Please ask for: Ms Iqraa Malik
Email: iqraa.malik@terraquest.co.uk
Telephone: 01212341390
Our Ref: AW/275/21/HH
Your Ref:
Date: 16th August 2021

Application for Planning Permission for Works or Extension to a Dwelling

Development: Proposed Rear Extension and Garage Addition
(This application may affect the character and appearance of the Craigwell House Conservation Area)
Location: 27 The Drive Aldwick PO21 4DU

Job title				
27 The Drive				
Drawing title				
Proposed Site Plan_Dimensions				
Status				
PLANNING				
Drawn by	Checked by	Date	Scale at A1	Scale at A0
		July 2021	1:100	-
Job No.		Draw No.	Revision	
		P101	-

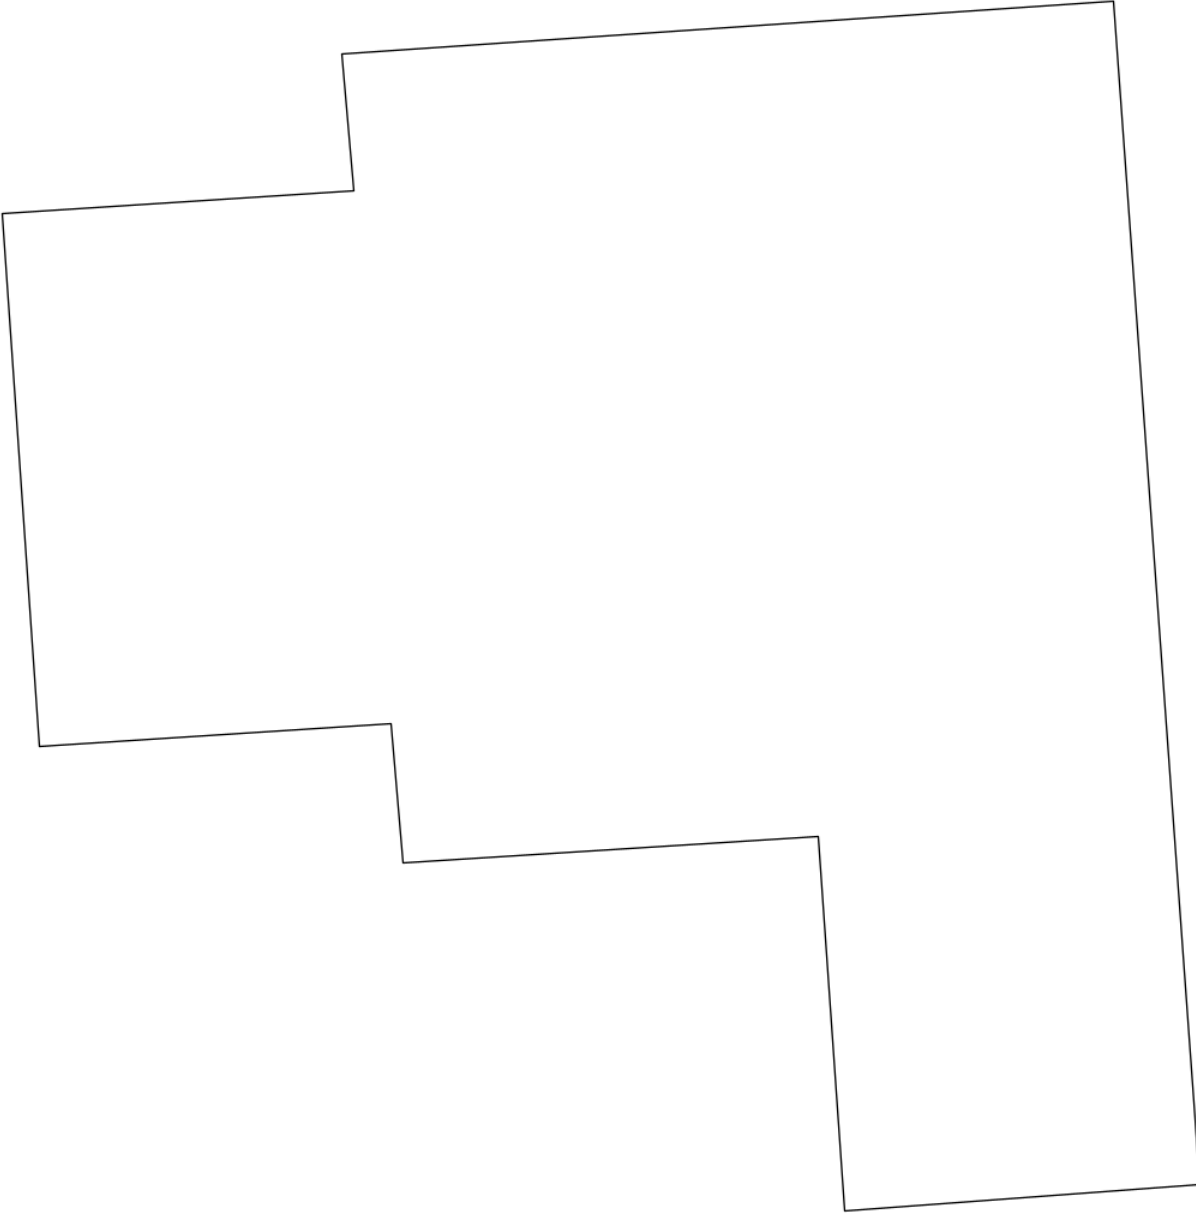
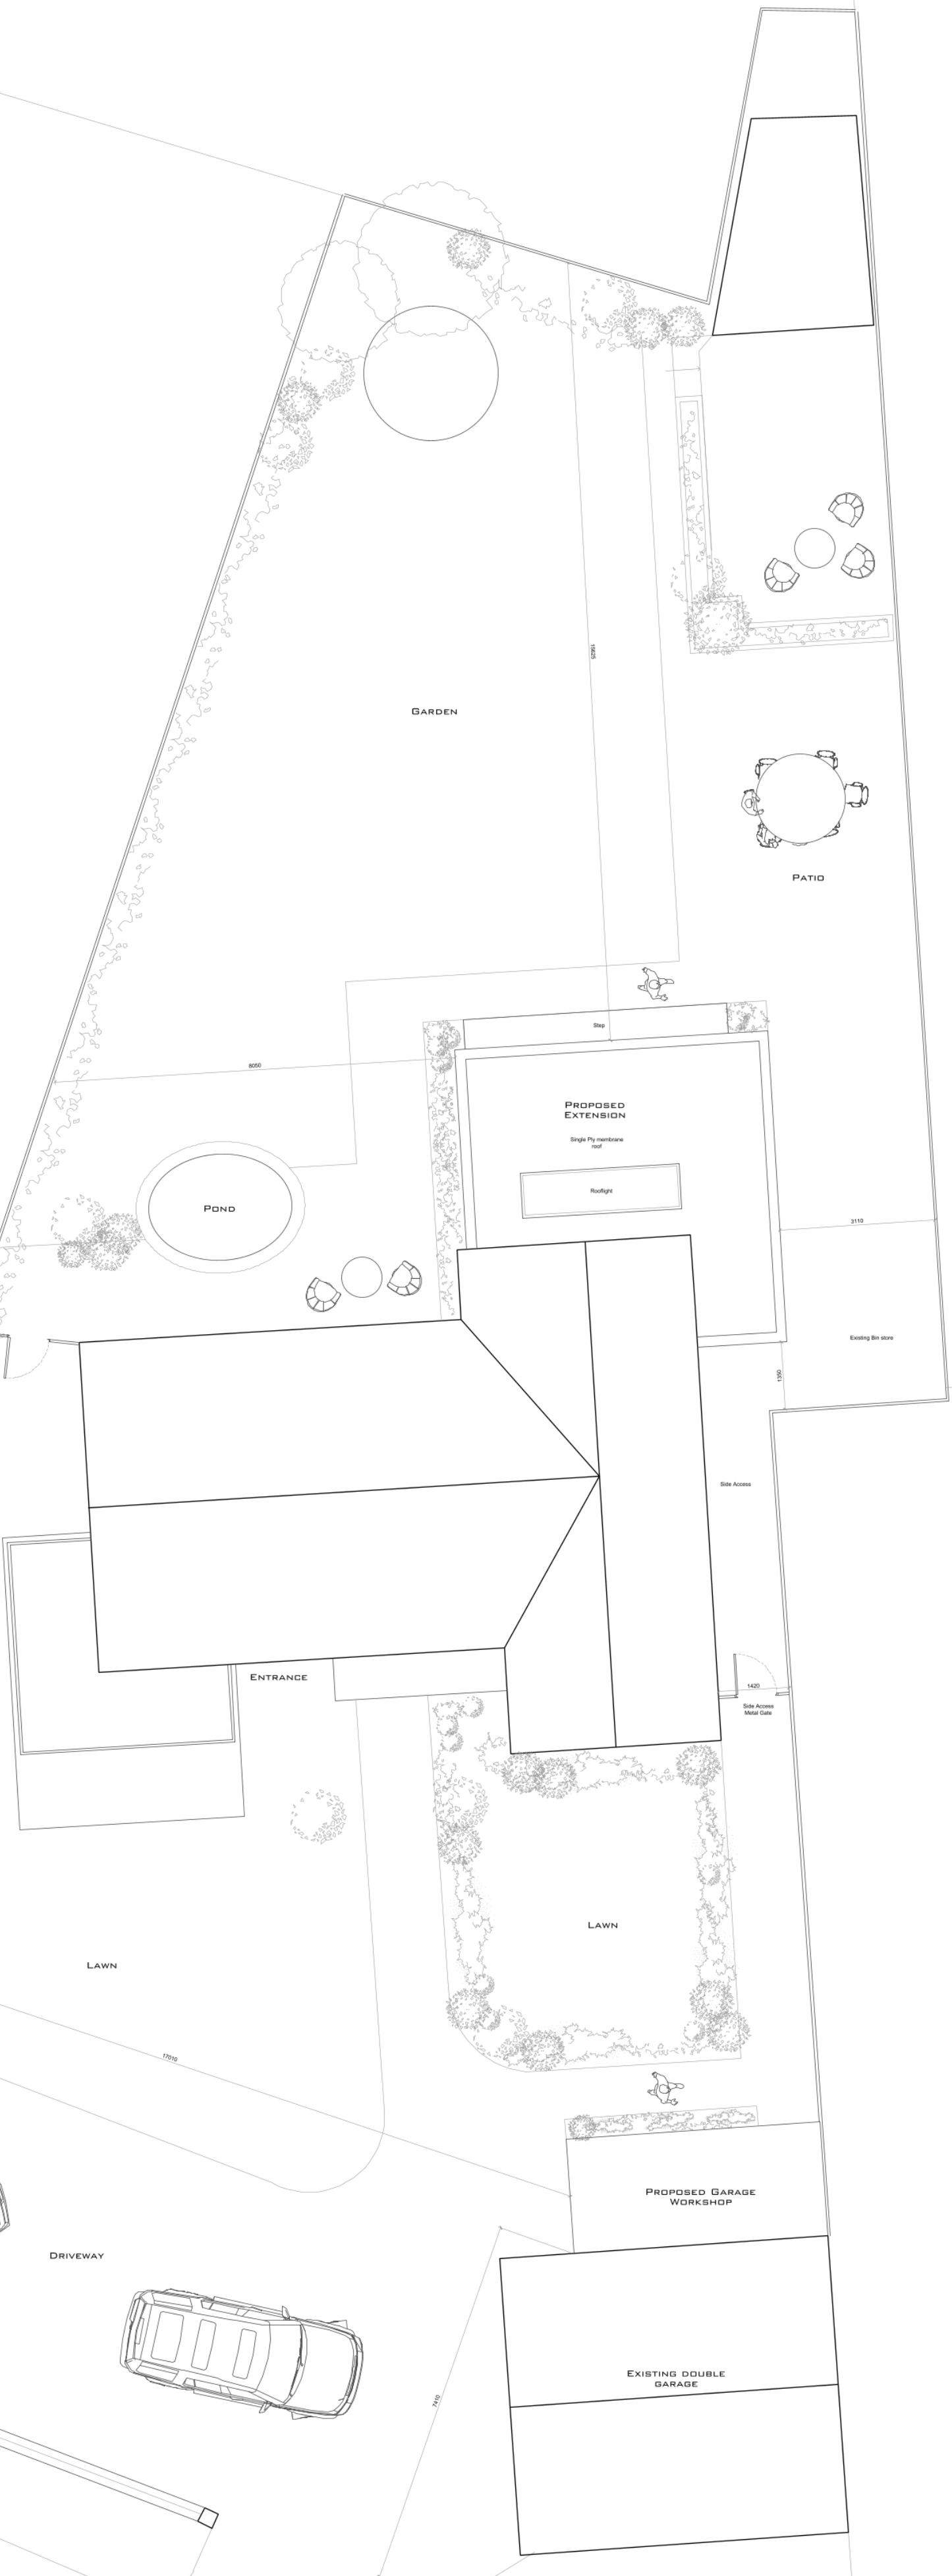
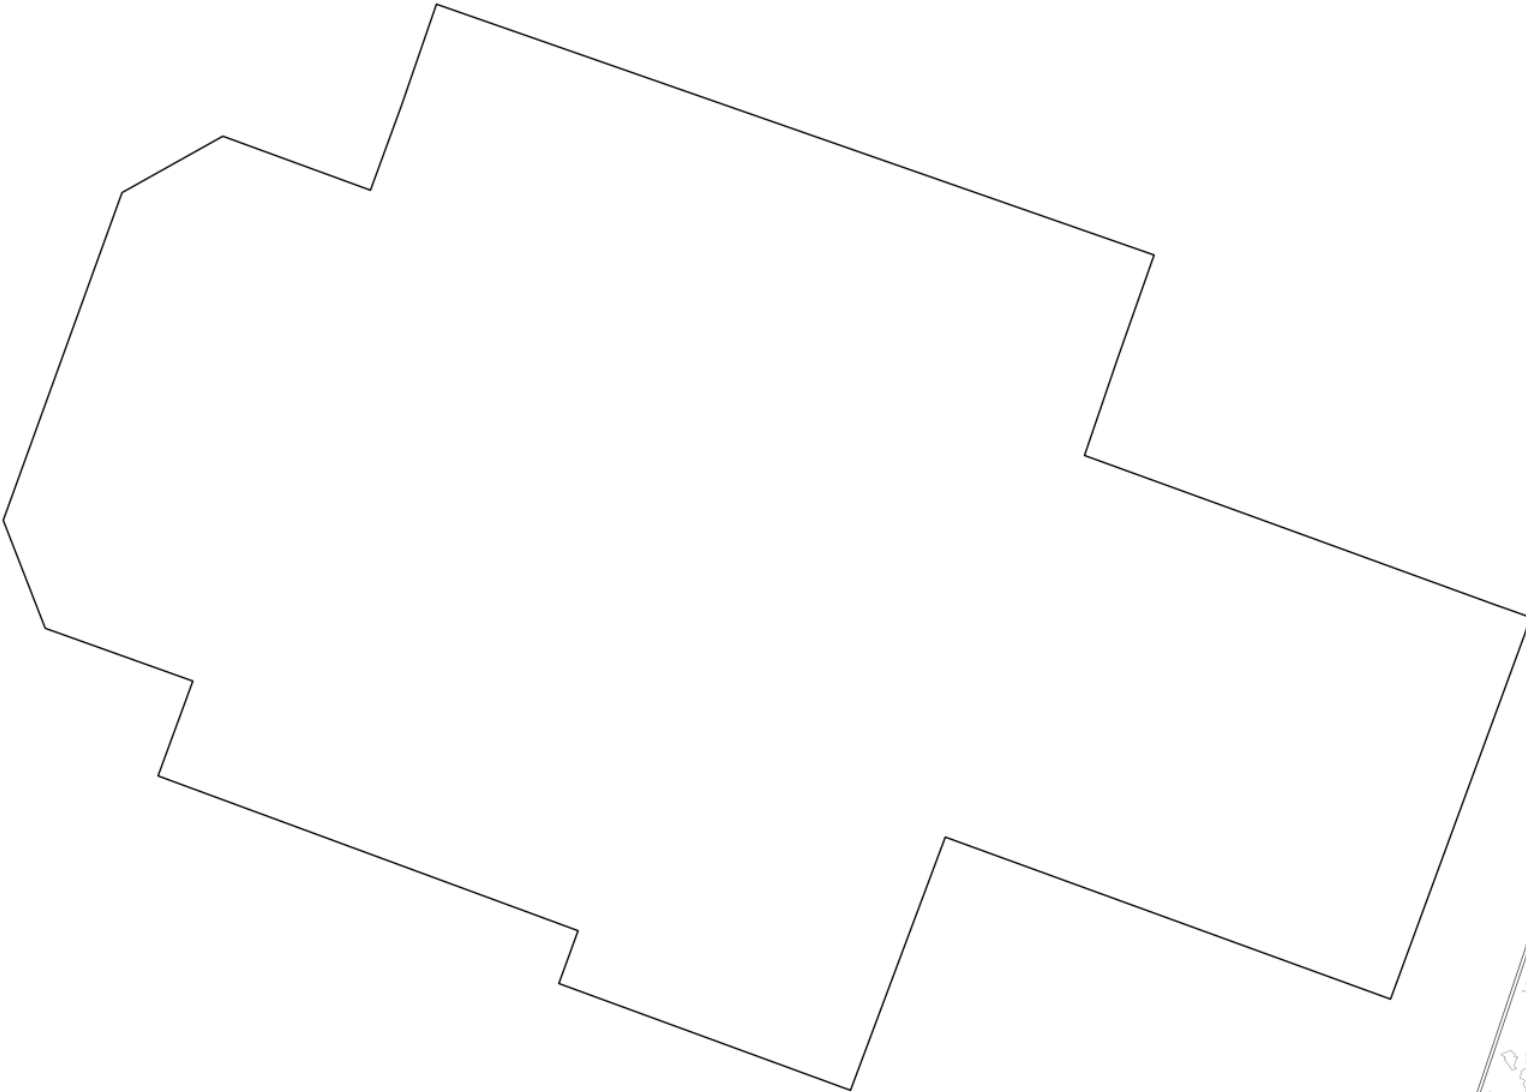
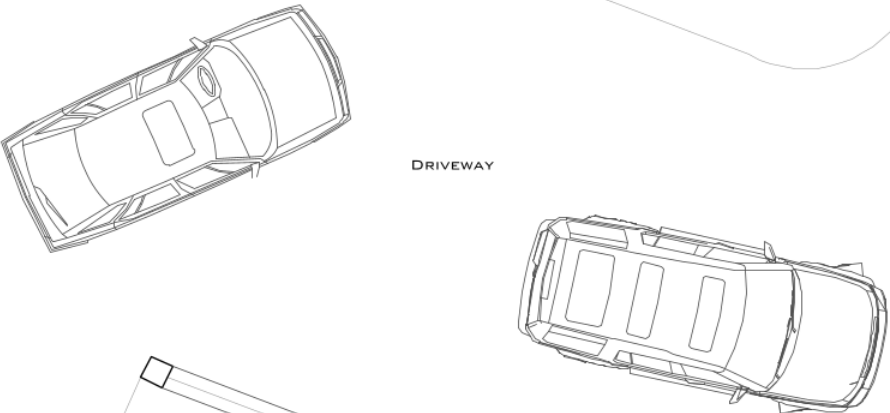
Dimensions: You are required to include dimensions on the block plan from the proposed extension to all site boundaries.
